From: Martyn White
Sent: 06 December 2021 17:11
To: Planning.Responses
Subject: BR/252/21/PL & BR/253/21/L

BR/252/21/PL & BR/253/21/L

65-71 Upper Bognor Road Bognor Regis PO21 1HR

Alterations to four listed buildings involving insertion of new windows, insertion of a new staircase, repairs and reinforcement of existing timber floors and roofs, removal of internal walls, forming openings in existing internal walls, erection of new internal partitions; extension of a listed building to create an office and warden's accommodation; erection of new building consisting of 3 No. flats, offices and workshops; creation of new private gardens, separation of this part of the site from the wider University campus, creation of a shared landscaped courtyard, creation of areas for parking and storage for bins and cycles.

Upper Bognor Road Residential Redevelopment Bognor Regis	
Drawing Charlotte House Elevations As Existing	
Scale @ A3 1:100	Drawing no. 5557-009-D1

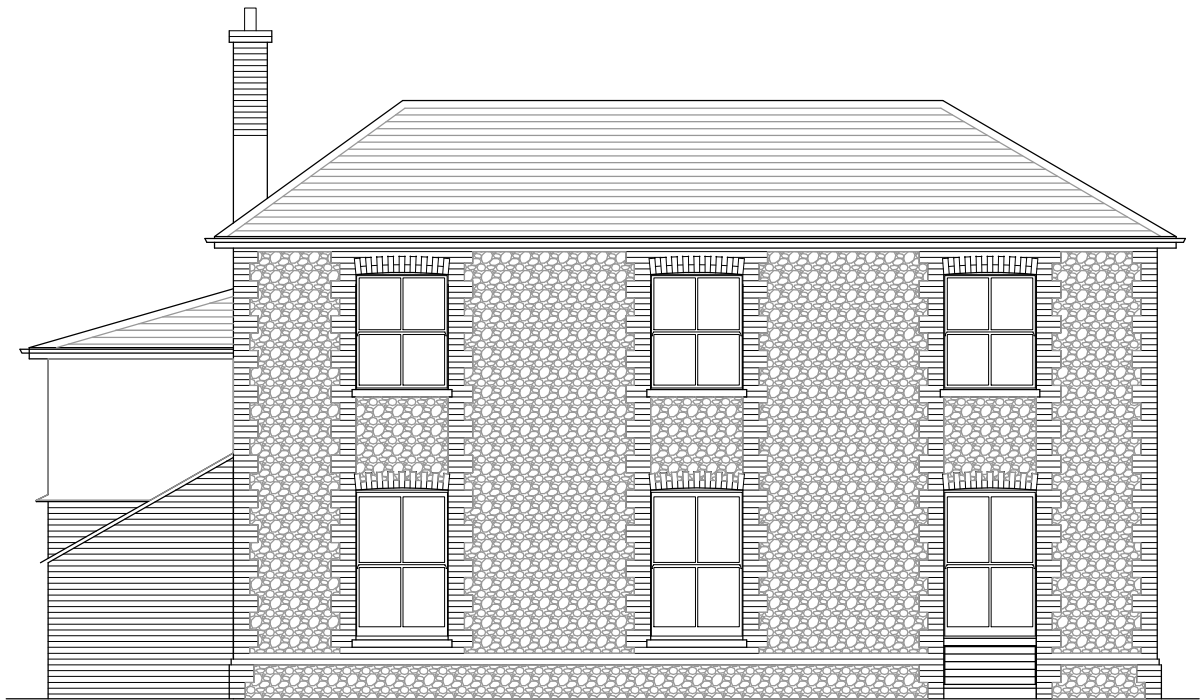
The works to Charlotte House comprise both internal and external elements. The external works relate to the provision of two new windows which will be located to the rear of the building, and would appear to replicate other existing windows. The internal works include the provision of a new staircase to a later extension, and the means to subdivide the building to create two residential units.

Such a proposal would seem to be acceptable, subject to detail of both the windows and how they recess into the opening. They should not sit flush with the surrounding wall.. Details of all windows doors and rooflights will be required in order to ensure that they are appropriate for the building and setting. Details will need to be of an appropriate scale and include details of the window

sections and glazing/glazing bars. All of the existing flints removed as part of creating the opening should be retained and used as part of the proposed works. Further, details of the new staircase and other proposed joinery and doors will also be required in order to ensure that they are suitable for the Listed Building.

Upper Bogmor Road Residential Redevelopment Bognor Regis	
Drawing 67 & 69 Upper Bognor Road Ground Floor Proposed	
Scale @ A3 1:50	Drawing no. 5557-101-D2

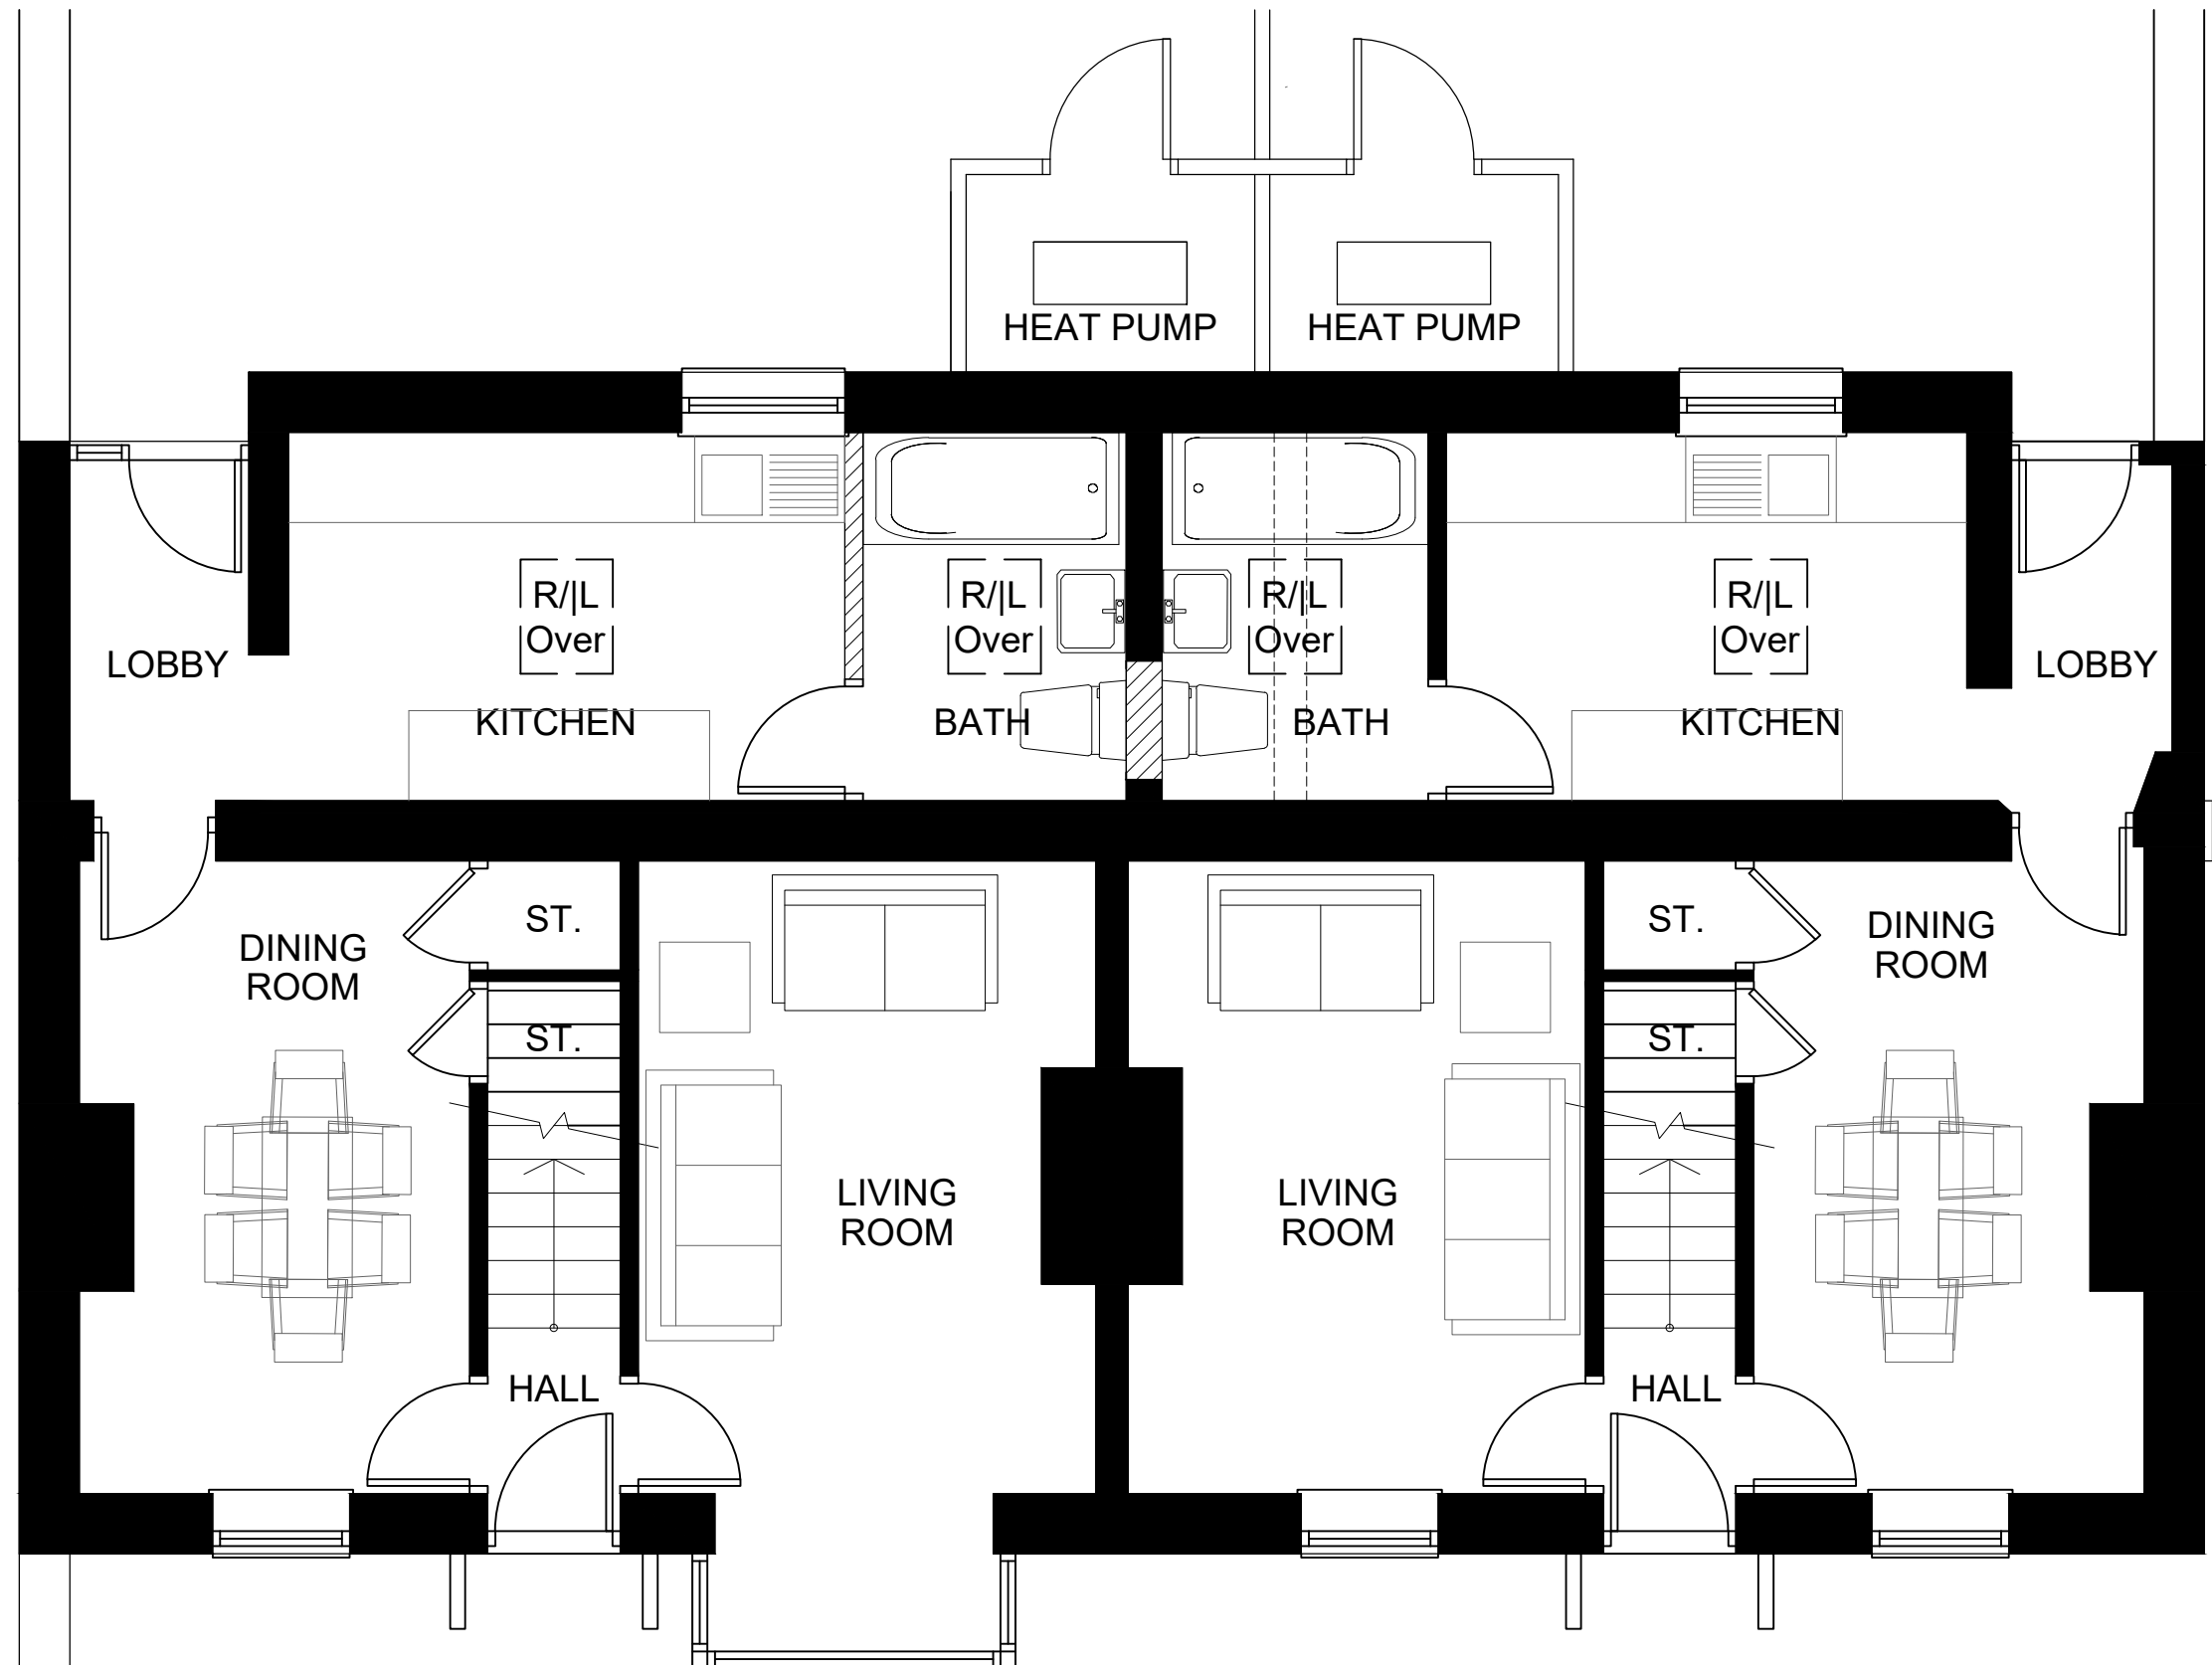
The structural works proposed to numbers 67/69 affect one section of wall in the rear outshot. This wall is to be re-aligned to reflect the rest of the wall dividing the two properties. Such a proposal will not cause harm to the significance of the building.

Due to the current condition, it is suggested that the remaining historic fabric should provide the starting point for the refurbishment of the cottages. For instance, the remaining simple, unmoulded skirtings should be replicated where missing. All works of reinstatement/repair should be undertaken using materials and techniques appropriate for the listed building.

Upper Bognor Road Residential Redevelopment Bognor Regis	Drawing no. 5557-112-D4
Drawing New Building Proposed Elevations	Scale @ A3 1:100

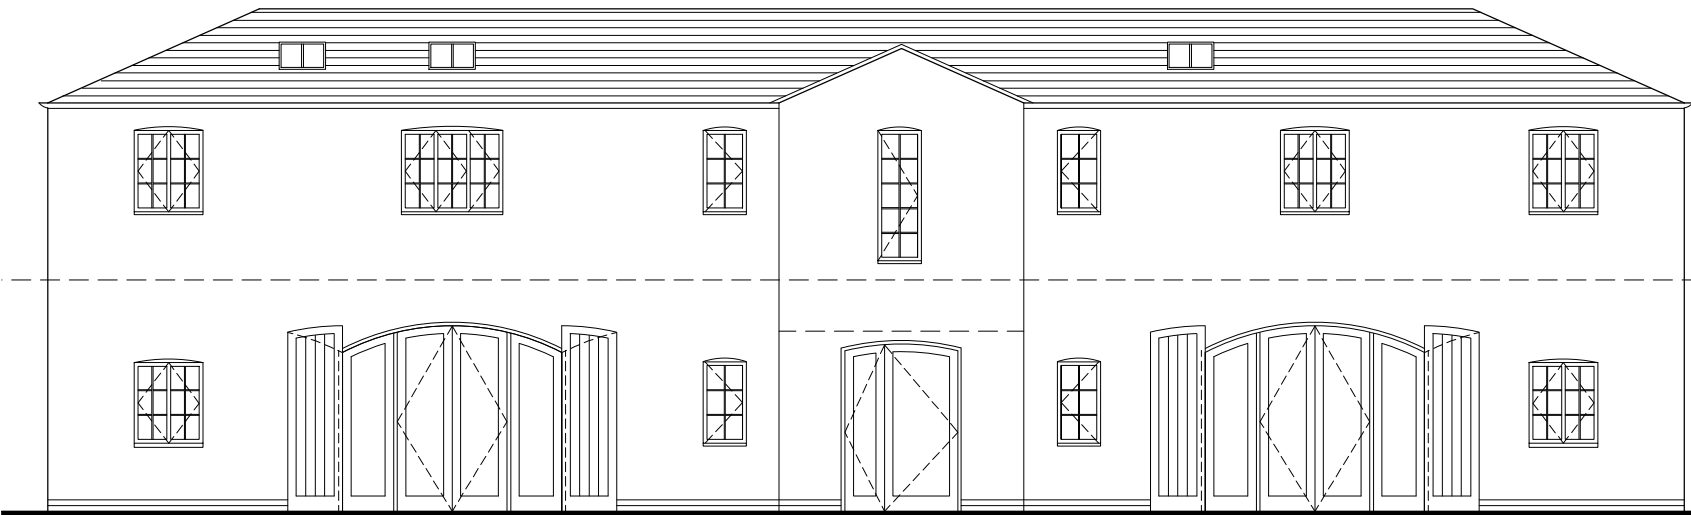
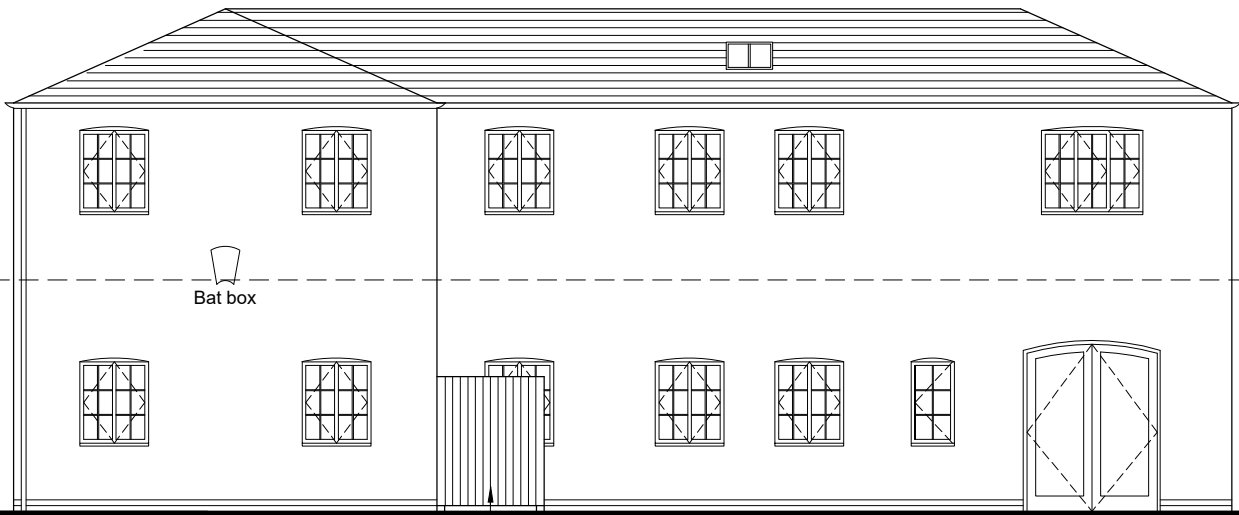
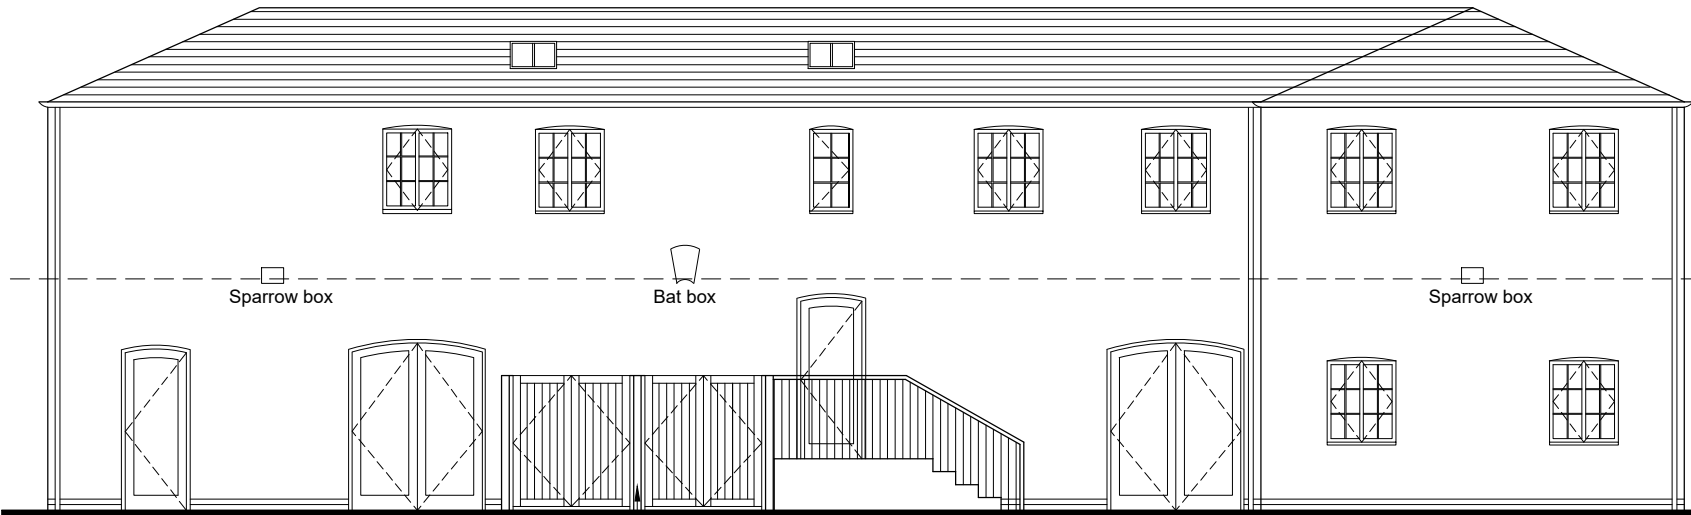
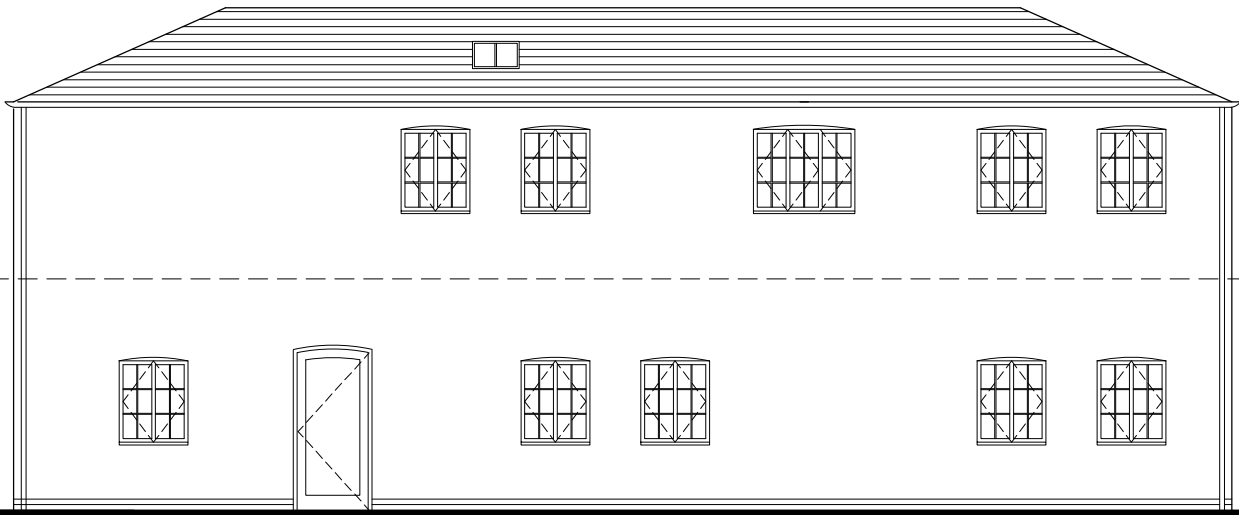
The proposed new building will accommodate both residential and workshop accommodation and will face 67 and 69, forming a courtyard with number 71. The existing group setting is of high significance, and development should be carefully considered and designed.

I note that the intention of the revised proposals is to glaze to the large workshop openings, whilst retaining the external timber doors which shall be folded back. This is a positive approach, and would ensure that there is greater activity in this element of the scheme. It would be positive if the timber doors were fully functioning. Whilst the proposed extension is larger than I had initially anticipated that it would be, if carefully detailed and high-quality materials are used, will have a neutral impact. Details of all windows doors and rooflights will be required in order to ensure that they are appropriate for the building and setting. Details will need to be of an appropriate scale and include details of the window sections and glazing/glazing bars. Windows should also be set back so as to create an attractive shadow line.

It is noted that the intention is for this new building to reflect the scale and appearance of the existing buildings. Such a concept is considered to be acceptable as long as it will truly reflect those already present, and not result in harm.

In fact, the proposed development will result in the creation of an attractive courtyard which will help to screen the adjacent new development from the existing listed buildings, along with this part of the conservation area. I would want to ensure that the landscaping of the courtyard is carefully considered so that it forms the centre of the scheme, as opposed to a hard landscaped area which detracts from the assets.
